Our ref: 26_36915_P

Your ref: H23-0845-26

Site Location: HIGHFIELD FARM CRANESGATE
NORTH WHAPLODE ST CATHERINE SPALDING
PE12 6SR

Summary of Proposal: Proposed extension

PROPOSED GROUND FLOOR PLAN
1:50

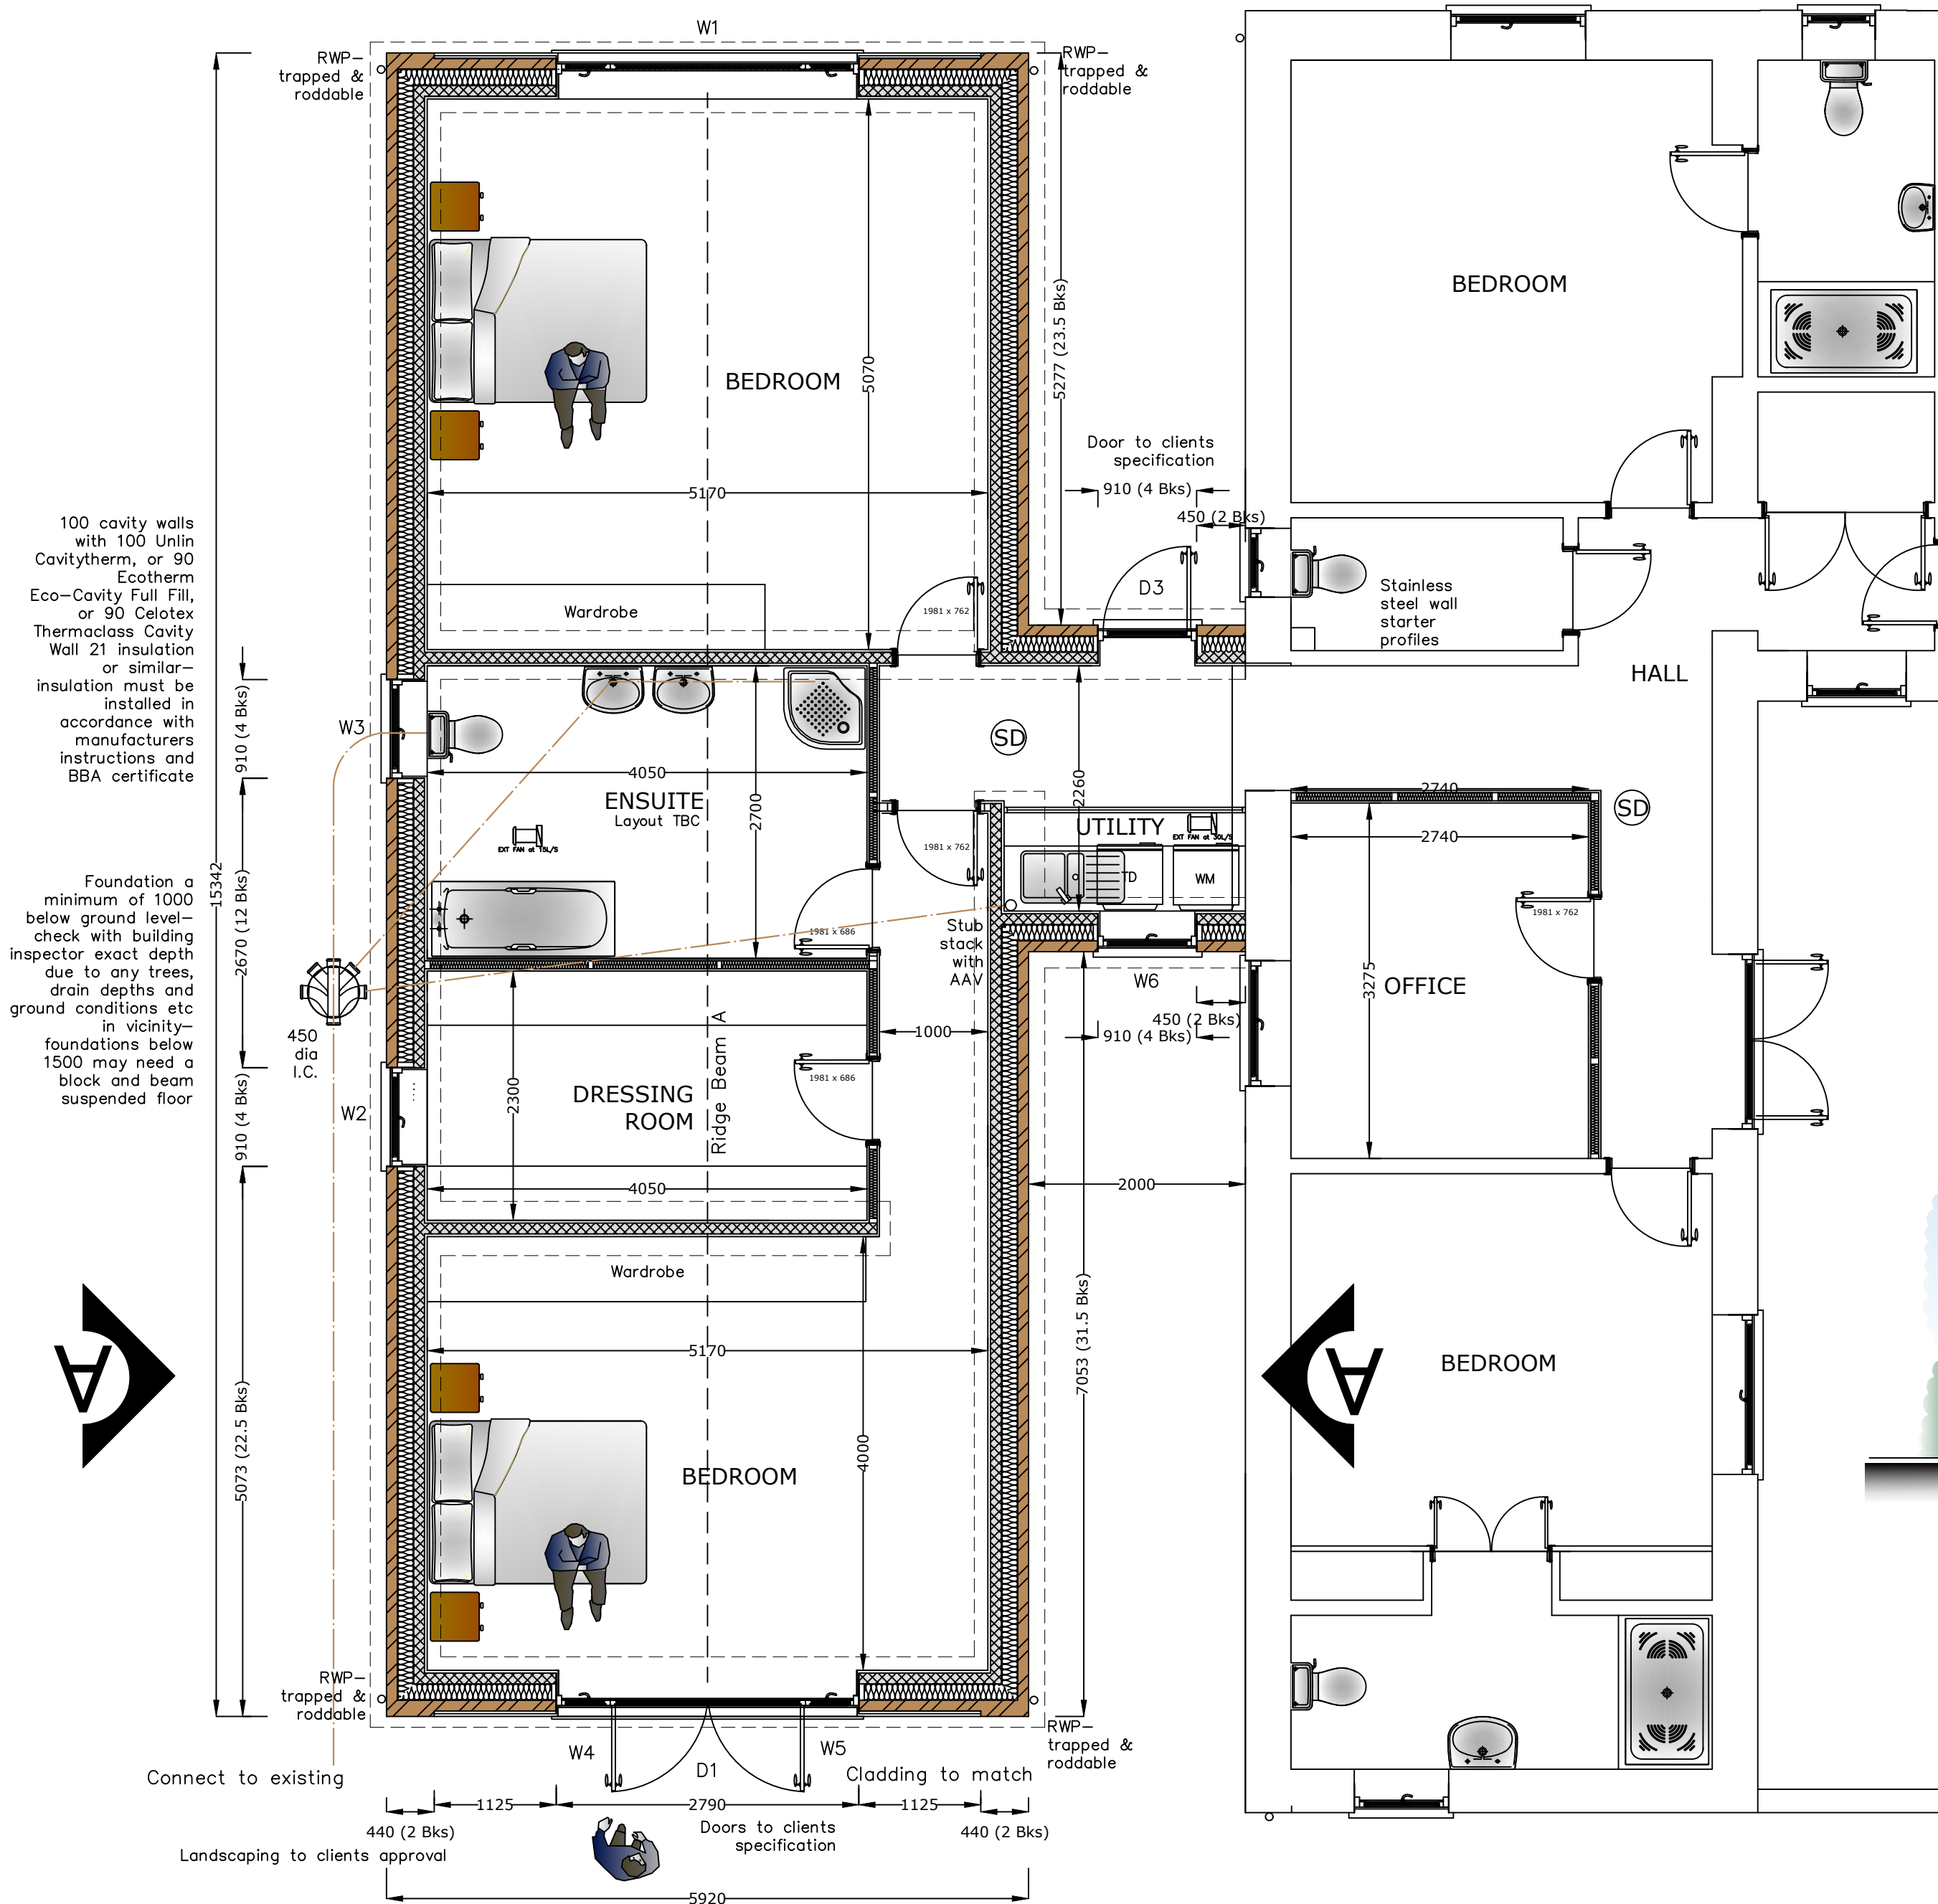
The applicant has indicated that they intend to dispose of surface water via infiltration, however I cannot see that the viability of this proposal has been evidenced. We recommend that ground investigation is carried out to determine infiltration potential, followed by testing in line with BRE Digest 365 if onsite material is considered favourable for infiltration.

If infiltration is not feasible at this site, following the drainage hierarchy we would expect the applicant to propose to discharge surface water to a watercourse. In this case, consent would be required under Byelaw 3. The Board recommend that any discharge is in line with the [National standards for sustainable drainage systems \(SuDS\)](#) published in June 2025. Further to the National Standards for SuDS, the Board's policy is to restrict discharges to 2/l/s/ha or annual average flood flow rate (QBar or QMed), whichever is higher.
